Group Northwest, Inc.

Subject: Geotechnical Evaluation for Alternative Locations
Proposed Residence
5637 East Mercer Way, Mercer Island, WA 98040

At your request, we are presenting our geotechnical evaluation for the alternative locations suggested by the City of Mercer Island for the proposed residence in order to minimize wetland intrusion.

SITE PLAN WETLAND AS REQUESTED BY CITY

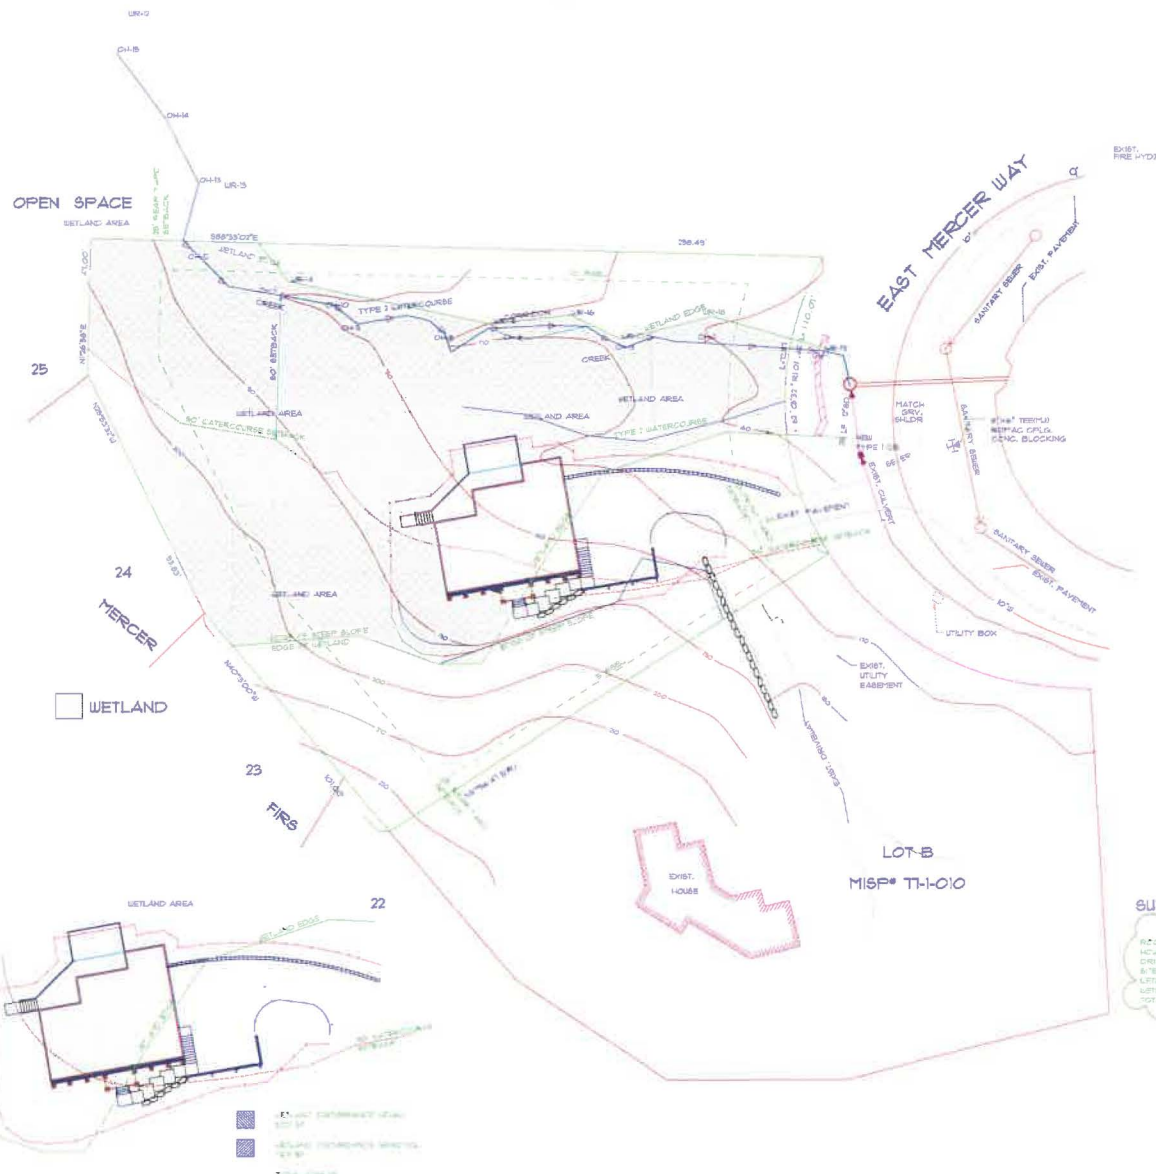
Accordingly, we have looked at the impacts of locating the house closer to East Mercer Way, and closer to the steep slope to the south as suggested by Mr. Evan Maxim from the City of Mercer Island.

The locations suggested by Mr. Evan Maxim do not work well from a geotechnical engineering perspective. They would intrude into the steep slope area, requiring the addition of a \$100,000 steel soldier pile shoring wall to retain the excavation, and the house would not have any windows at the west side, due to the shoring wall and the need for a catchment wall above it. The current location is preferable from a geotechnical perspective as it minimizes the adverse impact to the steep slope, improves the stability of the site and provides better access.
